**FINAL DRAINAGE REPORT
FOR
MC CLINTOCK STATION LOT A
(VOLLMER ROAD RV STORAGE)**

**May 2023
Project No. 25251.00**

PCD File No. PPR-2245

VOLLMER RV STORAGE PROPOSED DRAINAGE MAP

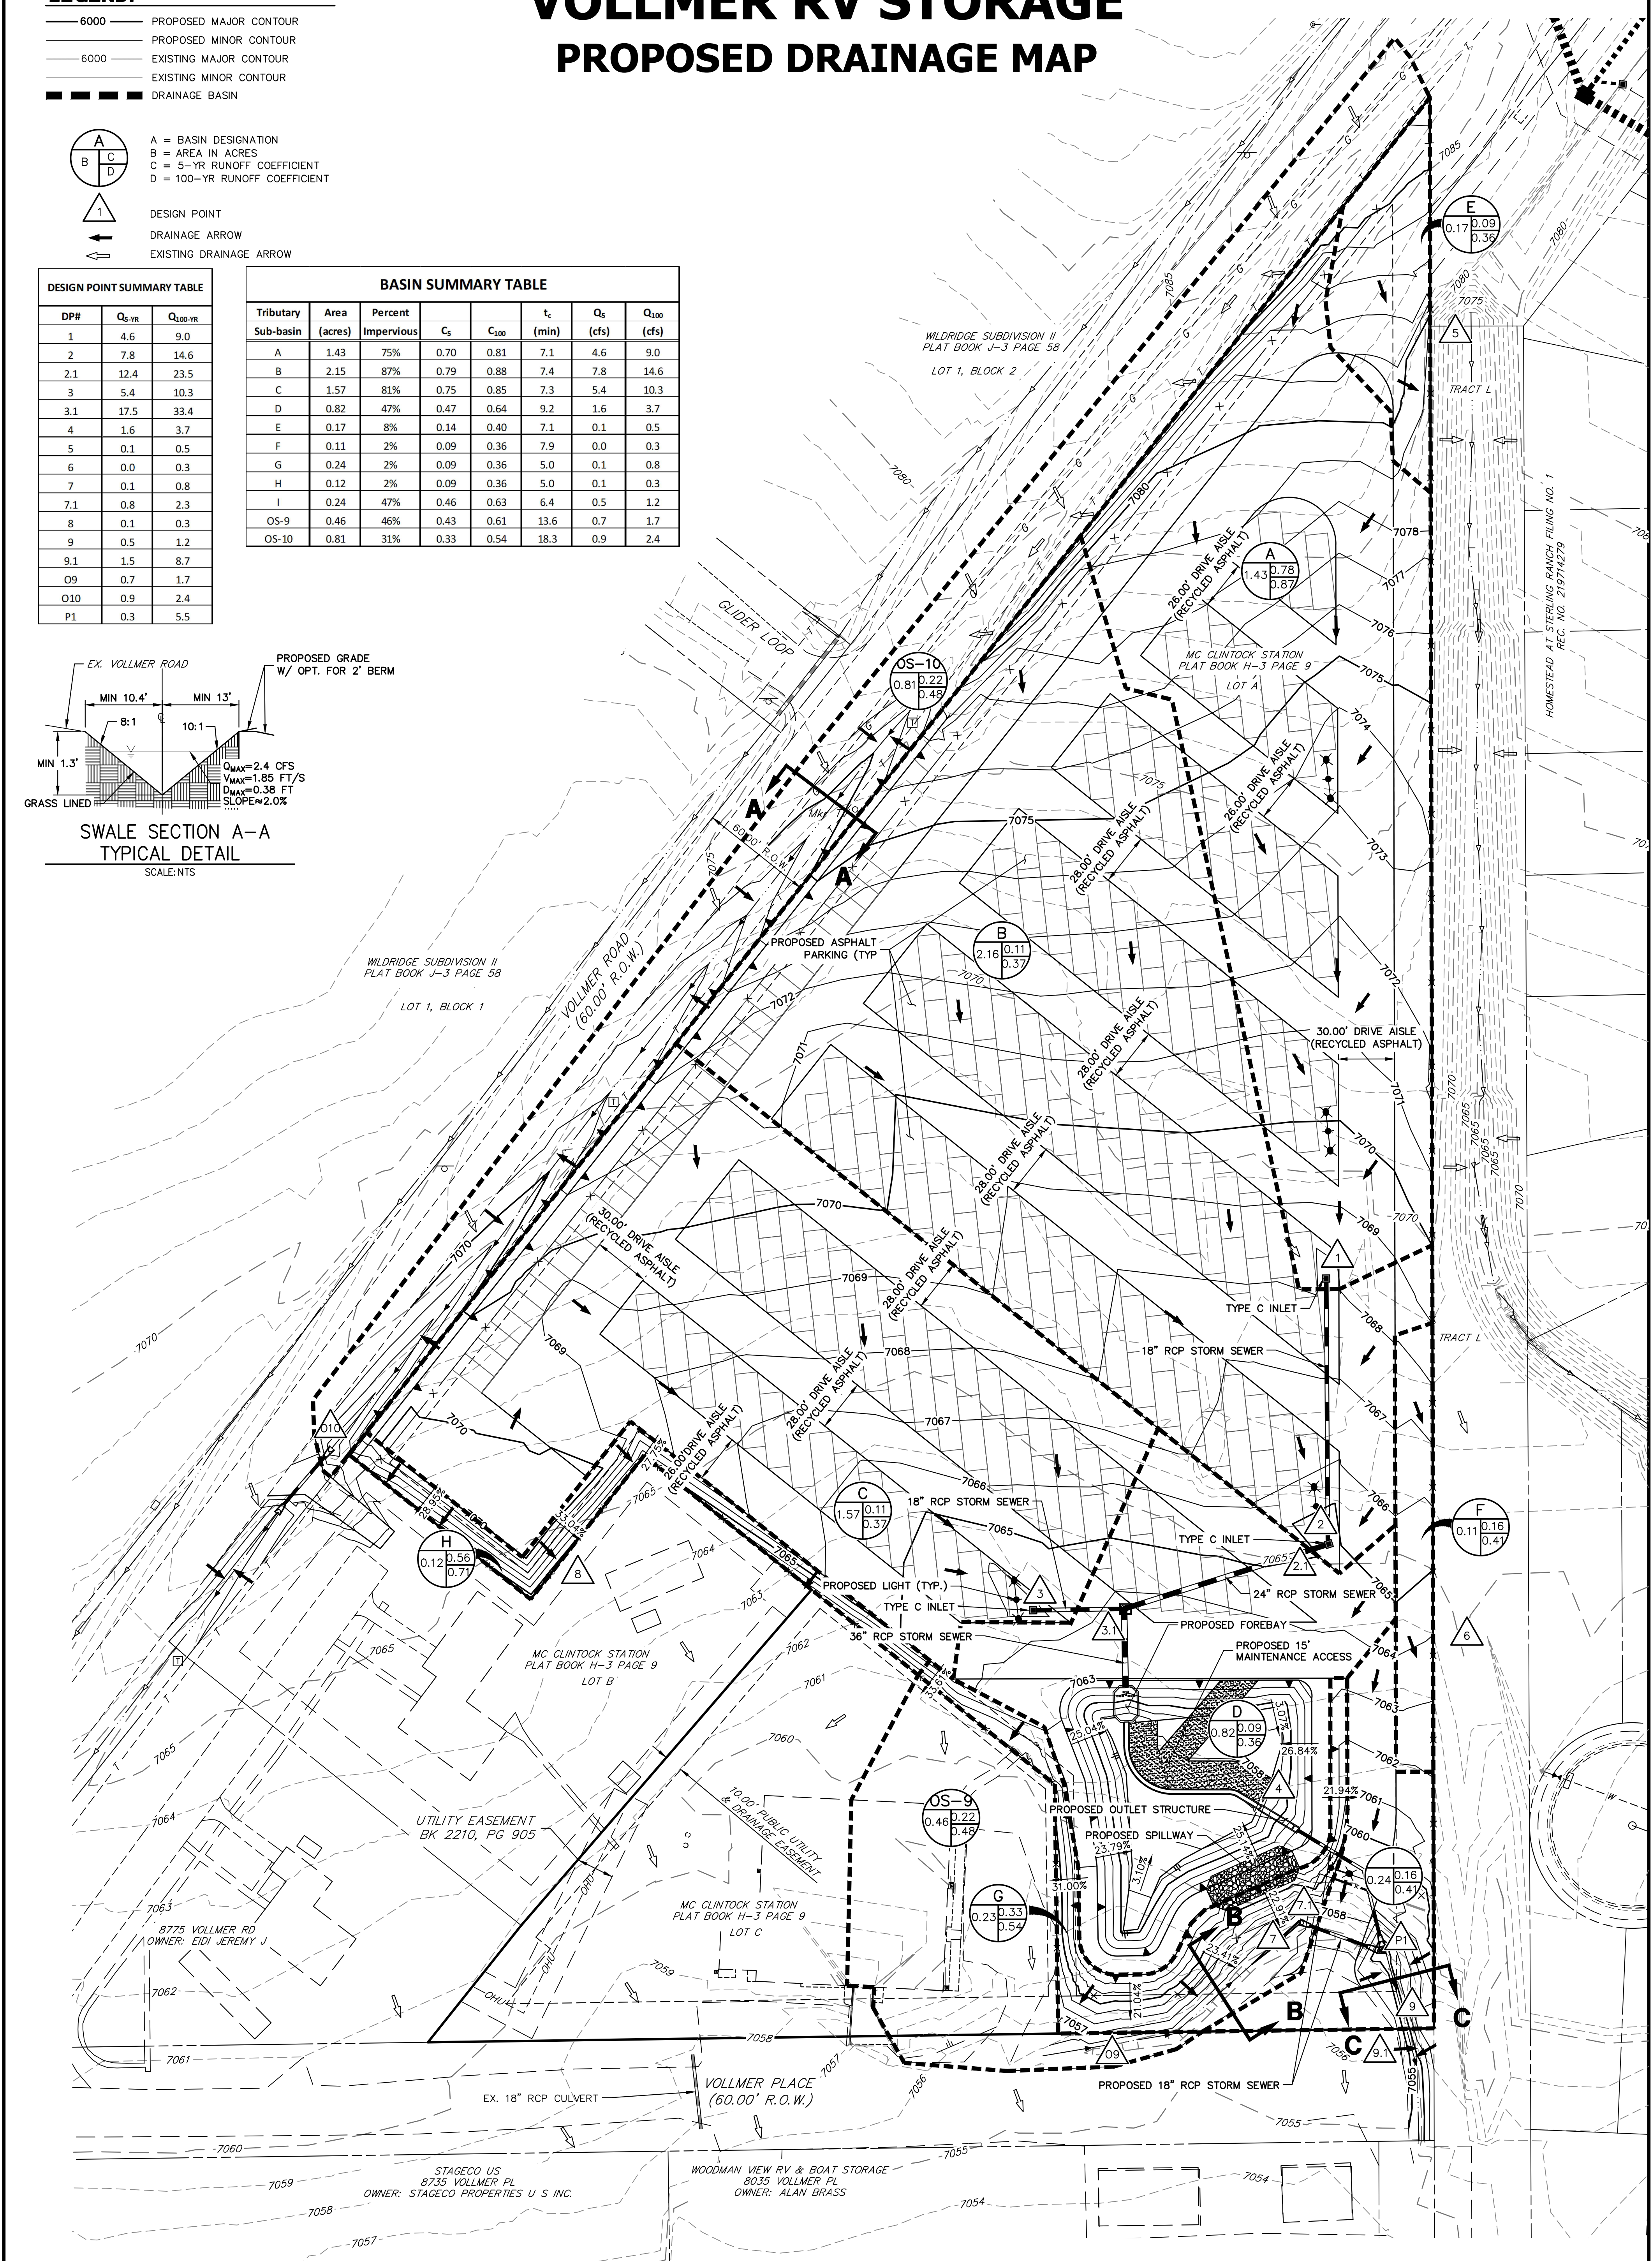
Address how flows differ from existing. Indicate where the existing swale for Homestead Filing 1 was designed with these flows.

Address how these flows differ from existing. Indicate if Homestead Filing 1 is able to accept or designed to accept these flows.

Address how these flows differ from existing

Address how these flows differ from existing

Flows don't match information in appendix.

Basin Area & flows do not match information in appendix

## PROPOSED CONDITION WATER QUALITY MAP

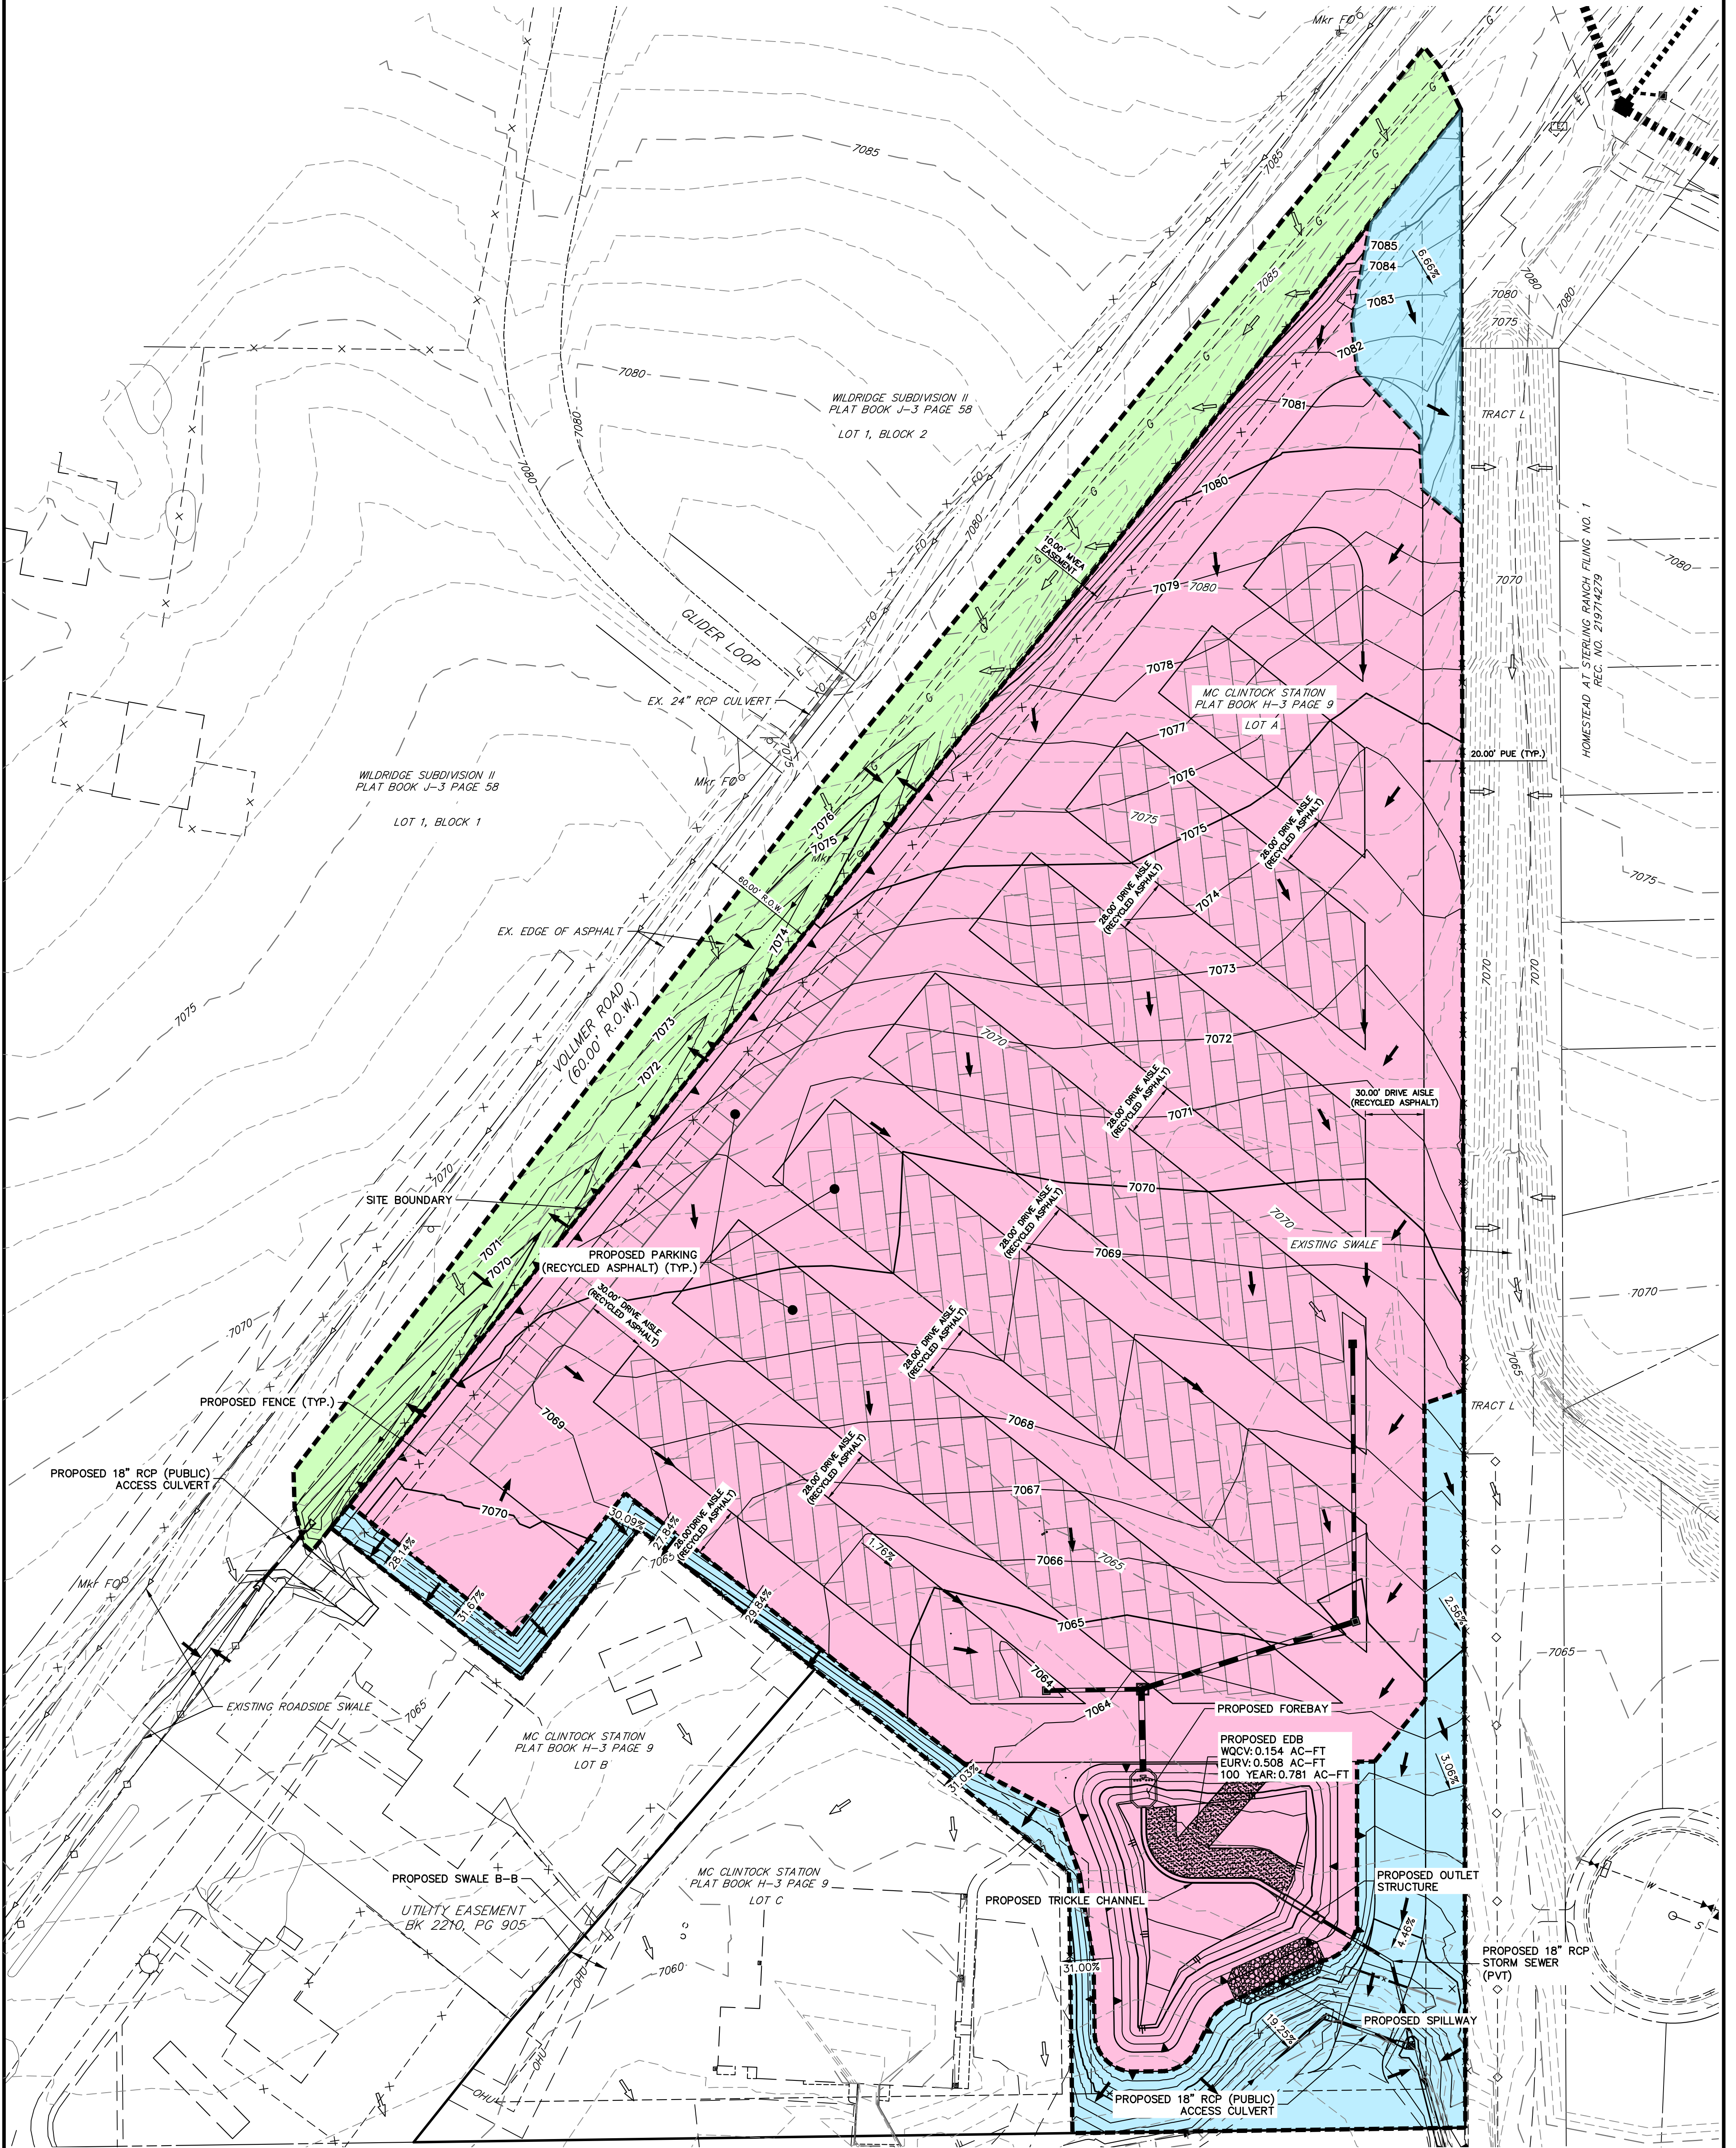
Need to discuss the portion of the site which is not being routed through the proposed pond and why it's not being treated. Include reference to portions of Appendix I which allow for this.
